# CITY OF ALBUQUERQUE

**Re: Opus Transport Apartments  
Traffic Impact Study (M15D023H)**  
Engineer's Stamp DRAFT  
Via email jroberts@tierrawestllc.com

The subject Traffic Impact Study (Study) draft received on June 17, 2024, has been reviewed by the City of Albuquerque Planning Development Transportation Section. The City has the following comments to be addressed.

Re: [2023065] – OPUS Transport Apartments – Flightway Ave. at University Blvd. in Albuquerque, NM.

**Figure 3B-23. Examples of Parking Space Markings**

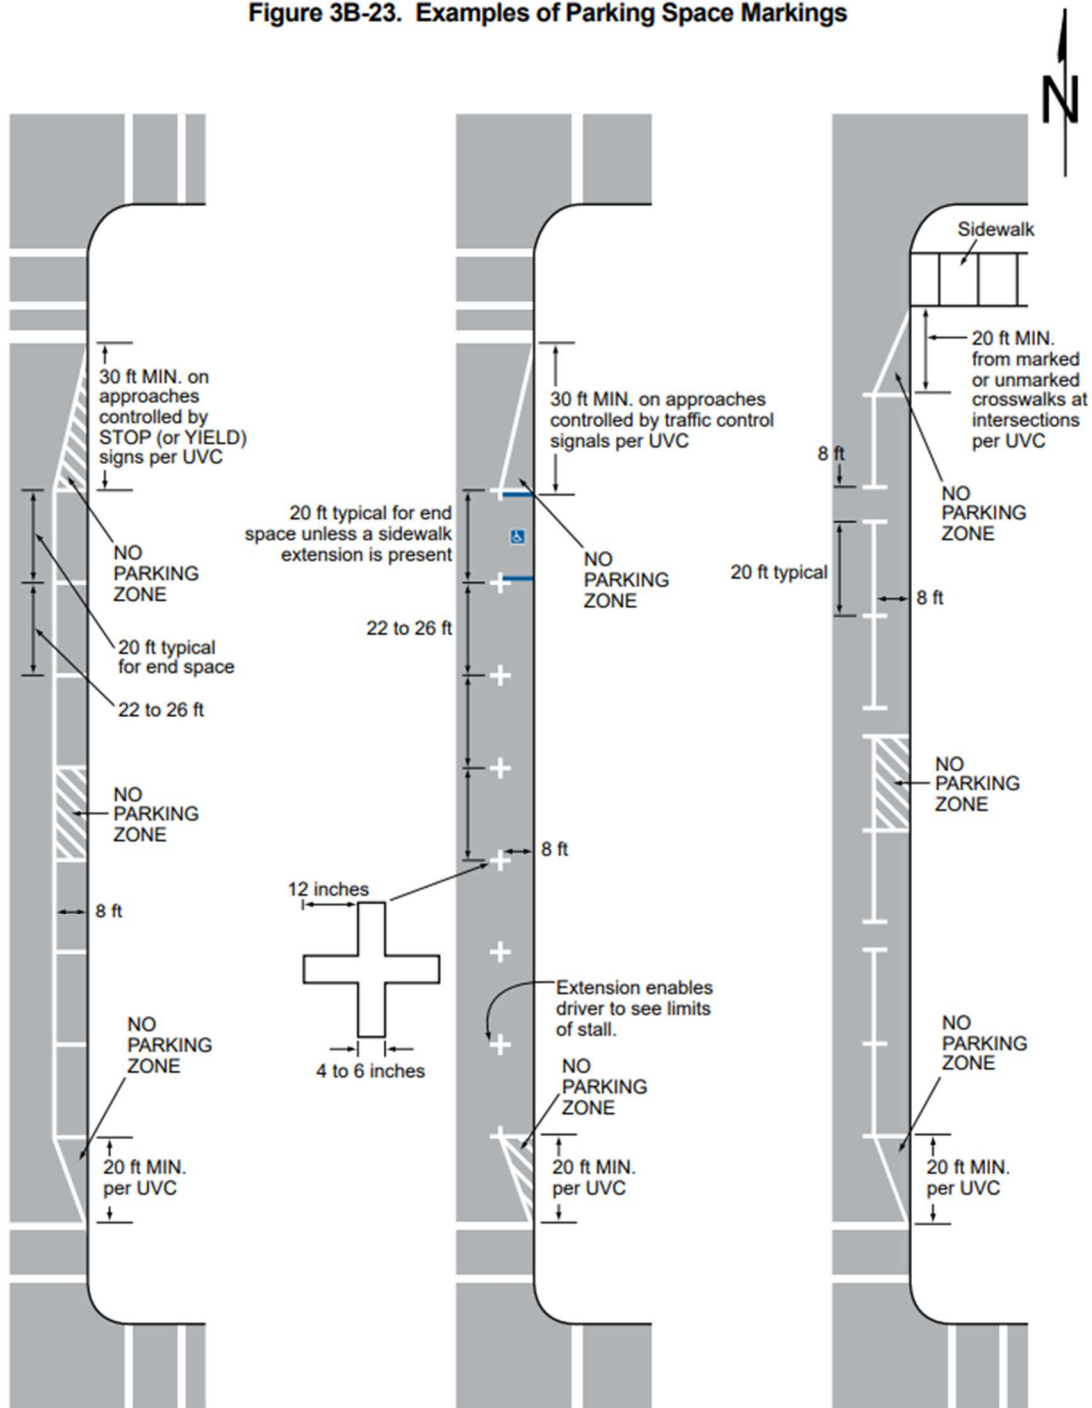
- c) Please extrapolate/provide details on the recommendation “Striping is recommended along the entire roadway to delineate lanes...”.

*The recommendation is to continue on-street parking along Transport St. on the east and west sides, as well as recommended improvements to the existing on-street pavement marking. Improvements include the striping of the parking space to meet MUTCD Section 3B.27 Parking Space Markings standard applies the following:*

*On-street parking space markings shall be white.*
